Your ref:
Our ref: 22/01131/F
Please ask for: Mrs Lesley Raby
Direct dial: 01553 616818
E-mail: borough.planning@west-norfolk.gov.uk

Details: **Variation of Condition 4 of Planning Permission 17/01916/F: Erection of cold store and staff facilities buildings at Alfred G Pearce Castle Road Wormegay King's Lynn Norfolk**

Figure 4 - Proposed alterations to existing cold store to form packing shed

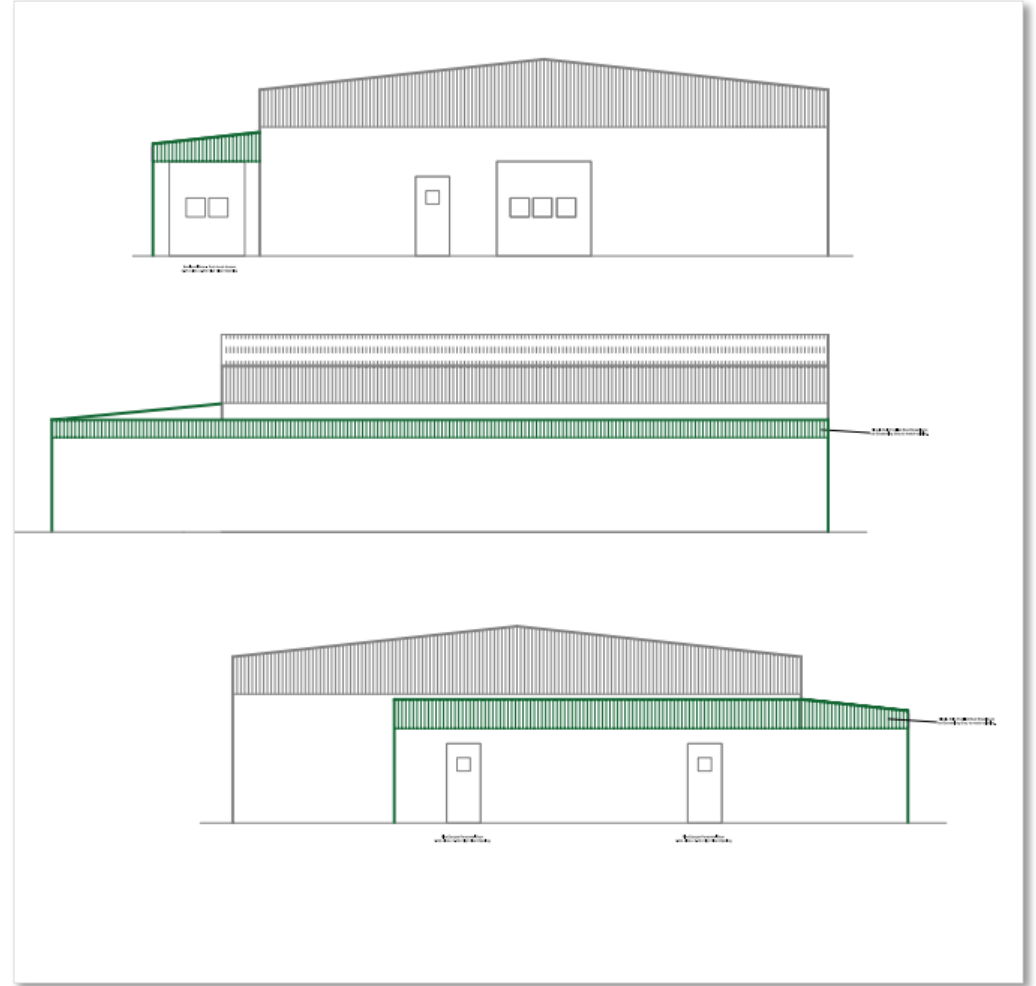
It appears that in addition to the use of the building (Variation of Condition 4) of 17/01916/F) you are proposing an extension to the building. The extension was not on the application form and no drawings were sent, although I acknowledge that this forms part of your Planning Statement. This means that Condition 2 also needs varying, to include the drawings for the extension.

1. Amended application form to include Variation of Conditions 2 and 4.
2. Scaled drawings, showing existing and proposed floorplans and Elevations.
3. Description amendment to application form, as (1) above, but also to include the extension.
